Thank you for the opportunity to comment on the Moonview Short Plat, SP-08-00051. Pursuant to the Memorandum of Agreement between Kittitas County and the Washington State Department of Ecology all the future residential well connections serving the proposed lots shall be required to have meters installed. Metering results shall be recorded in a manner consistent with Kittitas County and Washington State Department of Ecology requirements.

Thank you for the opportunity to comment on the short plat of approximately 40.01 acres into 4 lots within the AG-20 zoning district, proposed by L & D Land Corporation [SP-08-00051]. We have reviewed the application and have the following comments.

This letter is in response to your request for input related to the Moonview Short Plat (SP-08-51). I provide fire prevention and code review for Kittitas County Fire and Rescue (KVFR). KVFR has no code enforcement authority in this matter, so this input is strictly FYI. The following issues may need to be addressed during the development process:

SUBJECT: Moonview Short Plat SP-08-00051

**MOONVIEW SHORT PLAT**  
**PART OF SECTION 36, T. 18 N., R. 17 E., W.M.**  
**KITTITAS COUNTY, WASHINGTON**

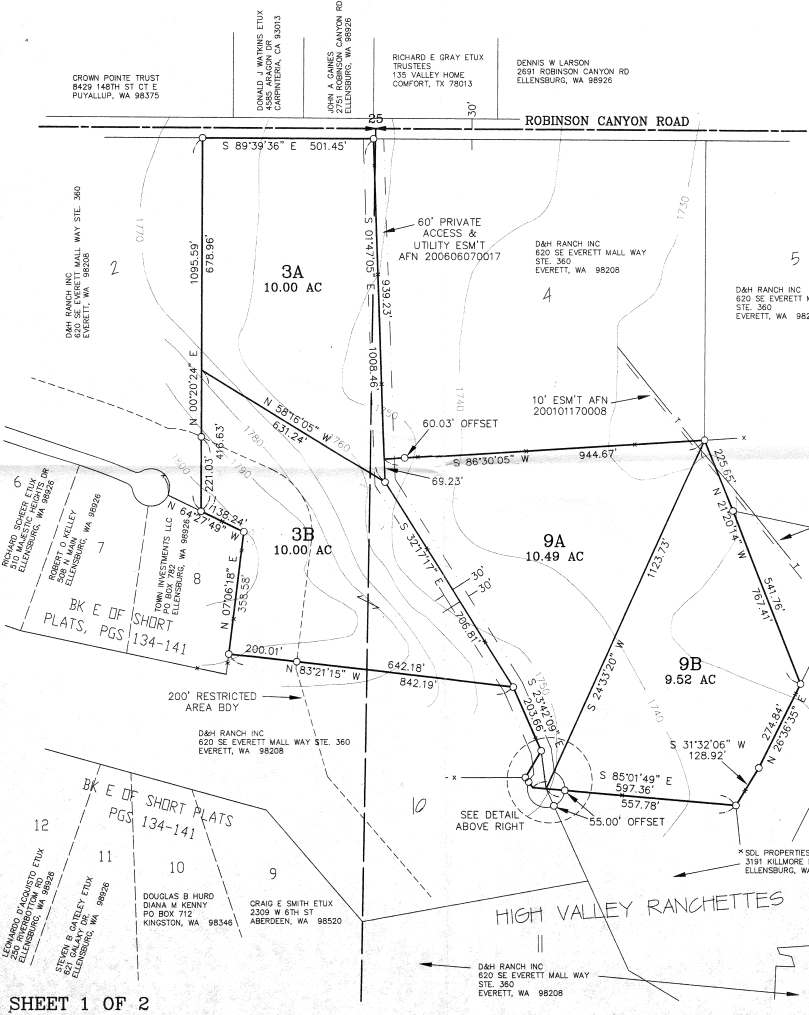
The potable water plat note is incorrect (plat note #8). Please replace the plat note with the following:

Please also include the following plat note:

3. Access: All access shall be from the 60' access easement.
4. Private Road Improvements: Access from Robinson Canyon to the cul-de-sac shall be constructed as a Low-Density Private Road. See Kittitas County Road Standards, 9/6/05 edition.

- a. Access easements shall be a minimum of 60' wide. The roadway shall have a minimum width of 20', with 1' shoulders, for a total width of 22'.
 - b. Minimum centerline radius will be 60'.

5. Cul-de-Sac: A cul-de-sac turn-around having an outside right-of-way or easement diameter of at least 110 feet shall be constructed at the closed end of all dead-end roads serving 3 or more lots. The driving surface shall be at least 96 feet in diameter. Cul-de-sacs must also conform to the requirements specified by the 2006 International Fire Code. Contact the Fire Marshal regarding any additional cul-de-sac requirements.

"The approval of this division of land includes no guarantee that there is a legal right to withdraw groundwater within the land division. The approval of this division of land provides no guarantee that use of water under the ground water exemption (RCW 90.44.050) for this plat or any portion thereof will not be subject to curtailment by the Department of Ecology or a court of law. "

"Metering will be required on all residential well connections and metering results shall be recorded in a manner consistent with Kittitas County and Washington State Department of Ecology requirements."
